Your Ref: 21/02885/REM

RE: Application for Non-Material Amendment (NMA) to that previously approved under reference no. 21/02885/REM at Land Between 6 And 10 Fern Road, Cropwell Bishop, Nottinghamshire.

FERN2/100/02/-

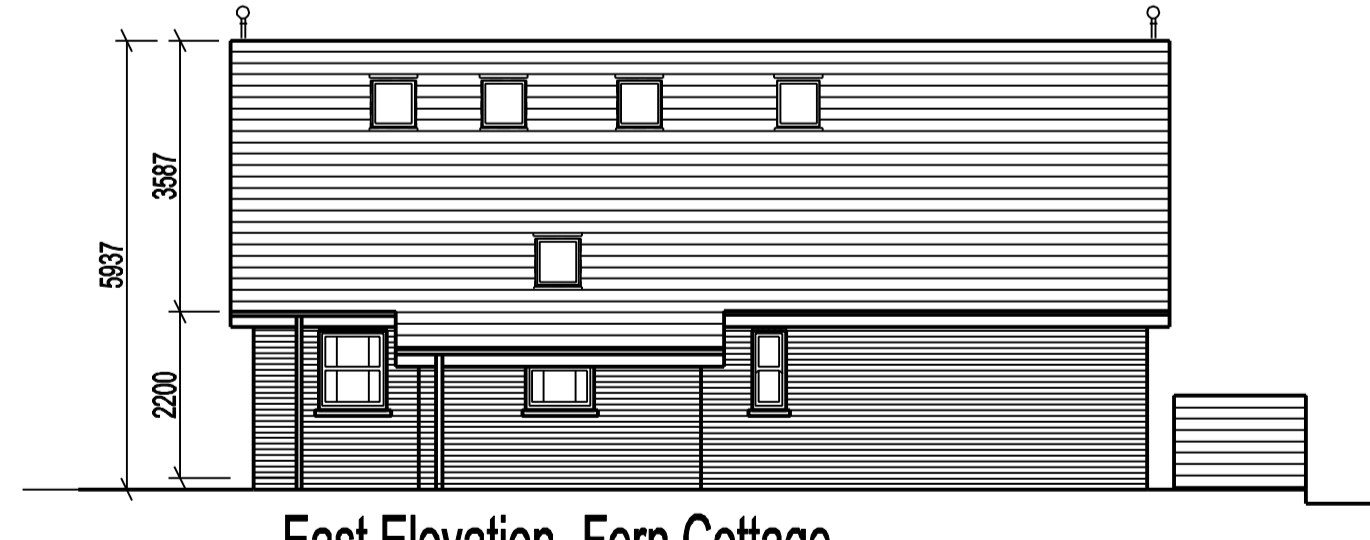
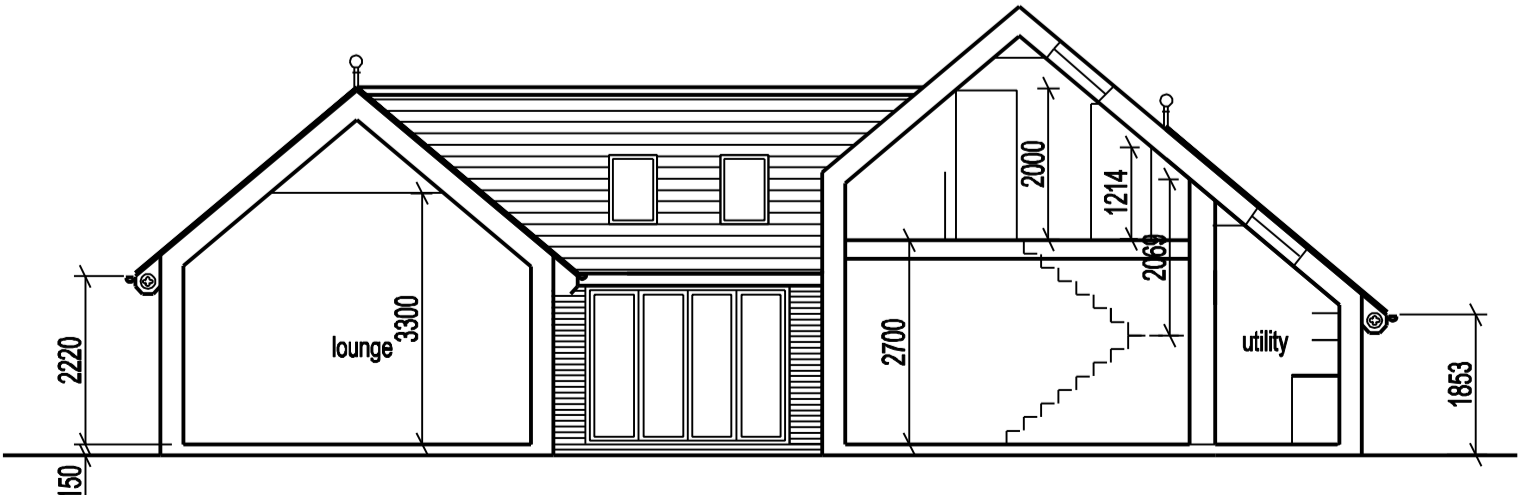
Instead of the arched windows that were previously approved, our client would now like to progress with an amended window/door openings design on two (front and rear) elevations, as shown below, to which this NMA application relates :
